Application for Planning Permission for Works or Extension to a Dwelling

Development: Proposed flat roof rear dormer to replace 3 no. hipped roof dormers
Location: Jasmine Cottage 4 Dukes Road Fontwell BN18 0SP

Proposed Elevations

① ELEVATIONS - AS PROPOSED  
Scale: 1:100

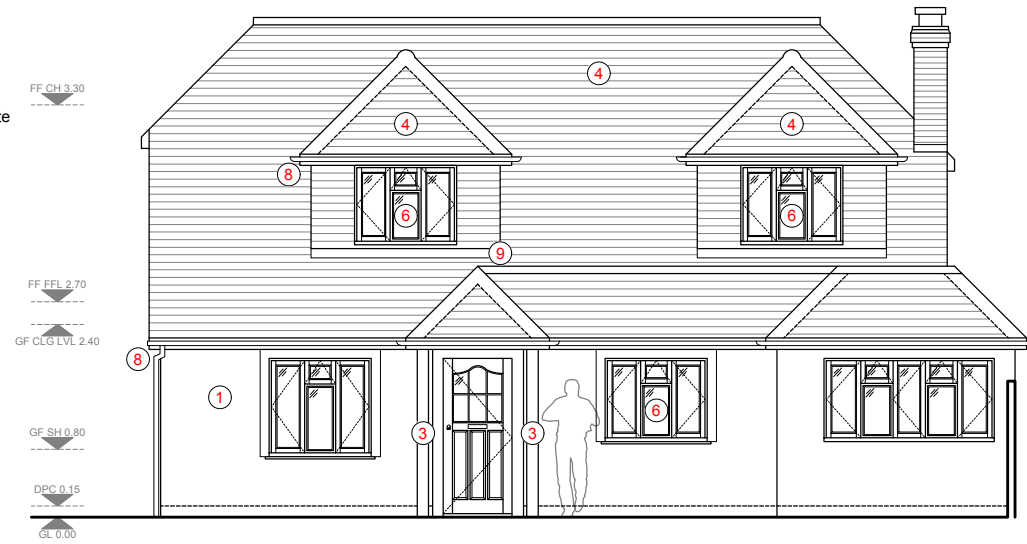
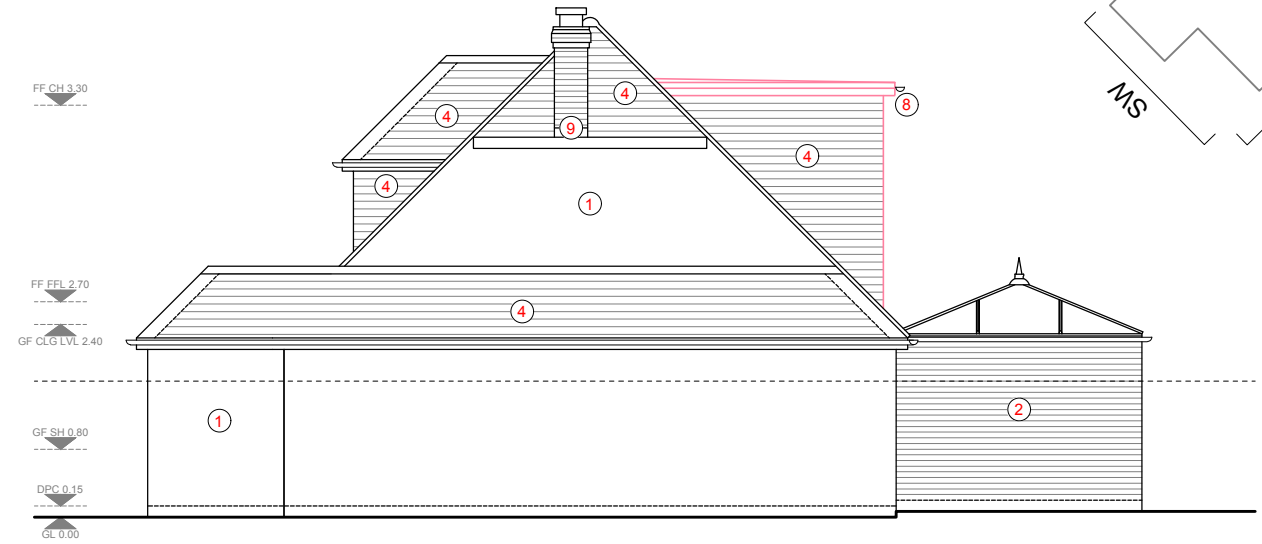
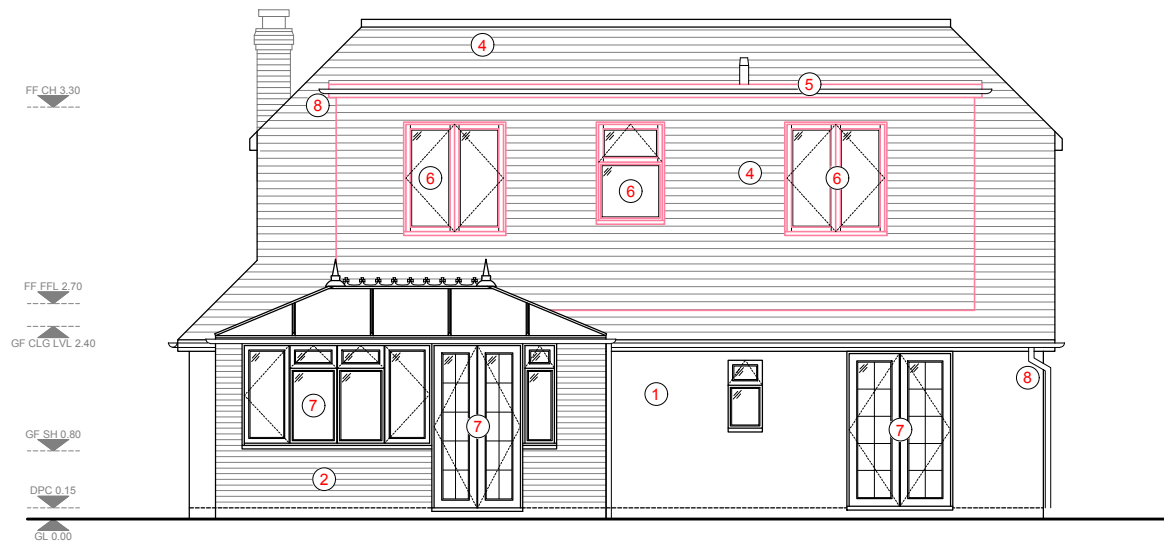
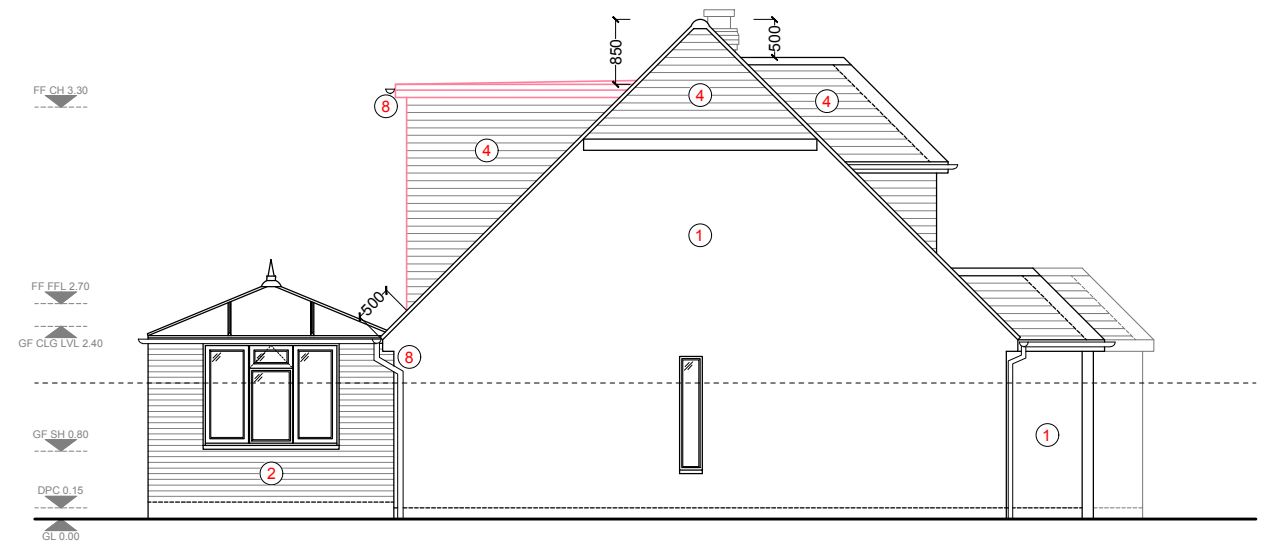
The proposed elevations have been labelled as existing, please review and amend.
